# Northland

May 20, 1996

RE: Portland Square  
Property Signage

NON-ILLUMINATED PLAQUES ON DRIVE THRU COLUMNS
SCALE: 1/2" = 1'-0"

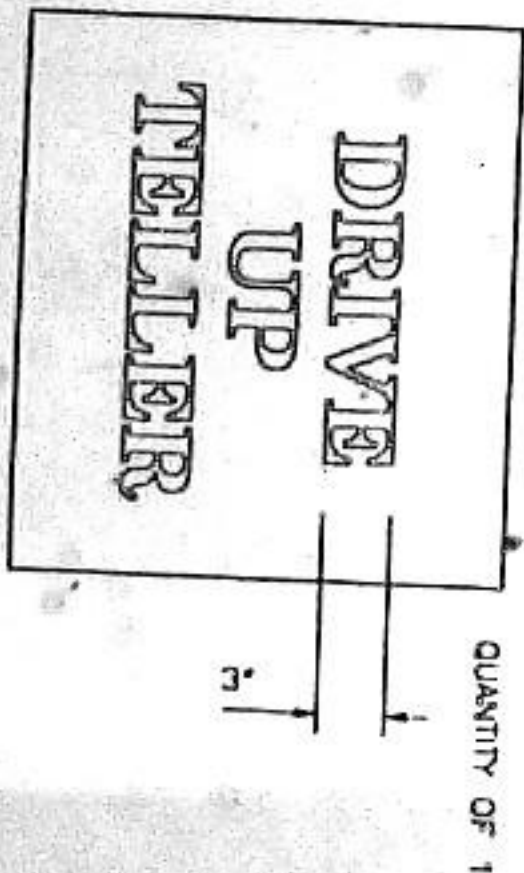
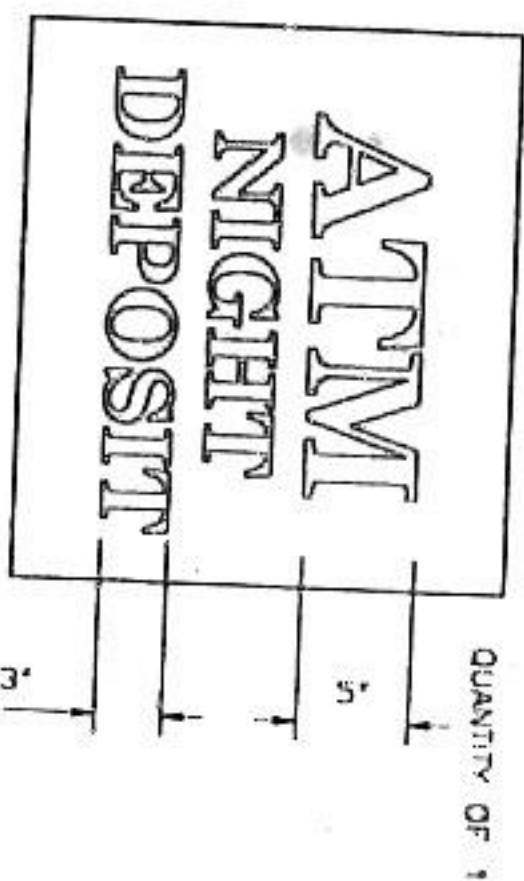
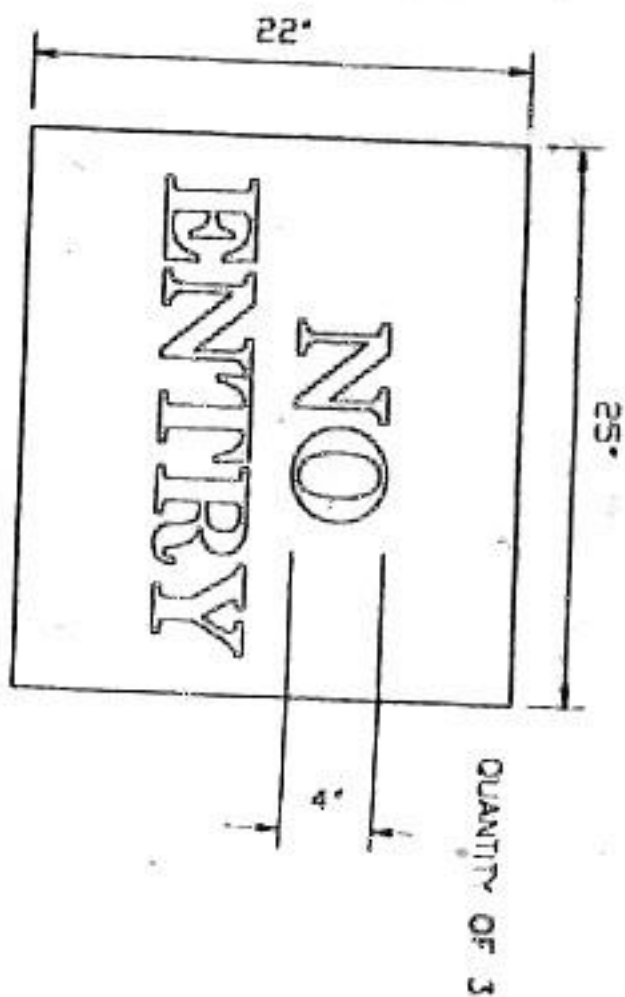
- The existing "reserved parking only" sign will not be updated nor received the PHB logo.
- The other property signs will not reference parking or use any directional arrows to indicate parking.
- The proposed signage changes to the drive thru canopy, columns, and cabinet are approved which include painting the cabinet bronze and install backlit signage on both sides of the cabinet. However, from a security standpoint, I would recommend the existing lighting levels of the drive thru area be reviewed against any legal standard necessary for such operations.

Please forward revised drawings and any City approval forms to me for signature.
